**Application Reference:** 6/2018/3292/FULL

**Proposal:** Non-material amendment- ref: NMA2

**Location:** Land adjacent to 45 Broadwater Road Welwyn Garden City AL7 3AX

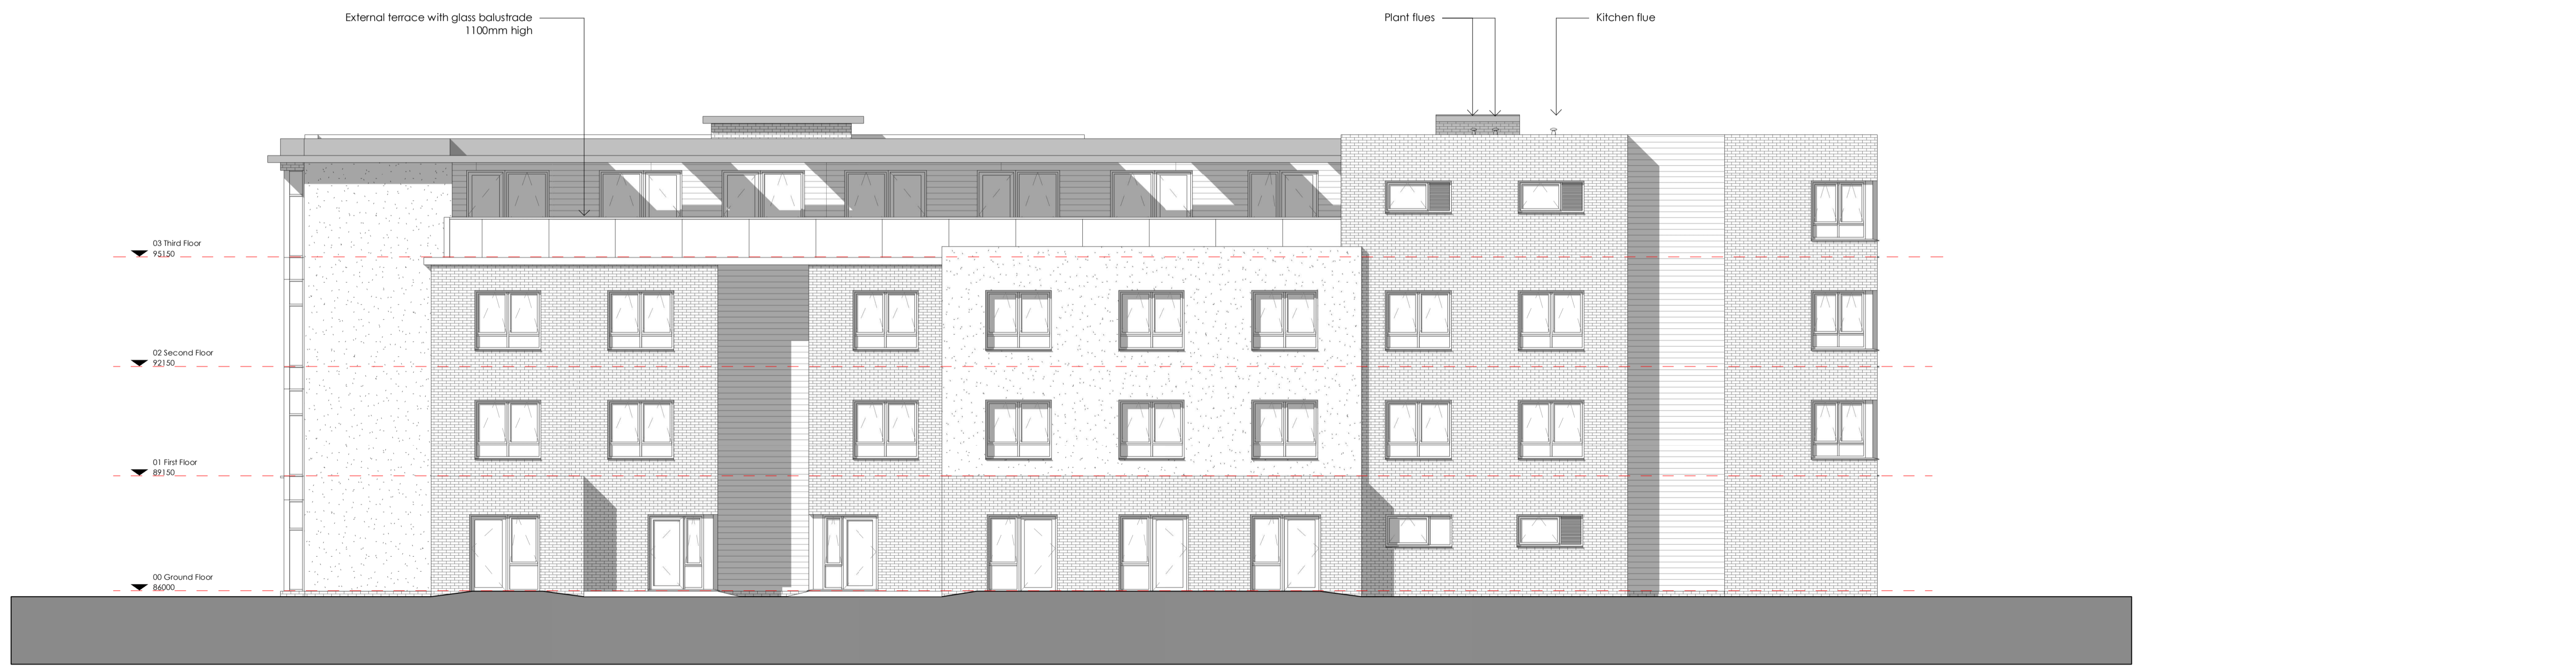
- Parapet heights across the scheme increased by 75mm due to implications arisen during construction.
- External terrace to Private Dining on third floor omitted and Private Dining size increased to infill the otherwise unused and inaccessible external space.
- Overall GIA increased due to item above. Area increase minimal at 5m<sup>2</sup> accounting to new total GIA of 5740m<sup>2</sup>.

Clarity has been sought on the overall heights of the buildings, which you have clarified in your email responses of the 27 and 29 July 2022 where you set out that the height increase by 75mm relates to the whole building including the main elevational features (taller elements facing the car park, Broadwater Road and the

courtyard). You have explained that this is proposed in order to retain the original proportions between the main parapet and the taller features.

310 C Site Plan – As proposed  
17-132-123J- Third Floor Plan  
17-132-124E - Roof Plan  
17-132-150G - Elevations - Sheet 1  
17-132-151F - Elevations - Sheet 2  
17-132-152C - Elevations - Sheet 3  
17-132-153E - Street Scene Elevation  
17-132-155F - Indicative 3D Views - Sheet 1  
17-132-156F - Indicative 3D Views - Sheet 2
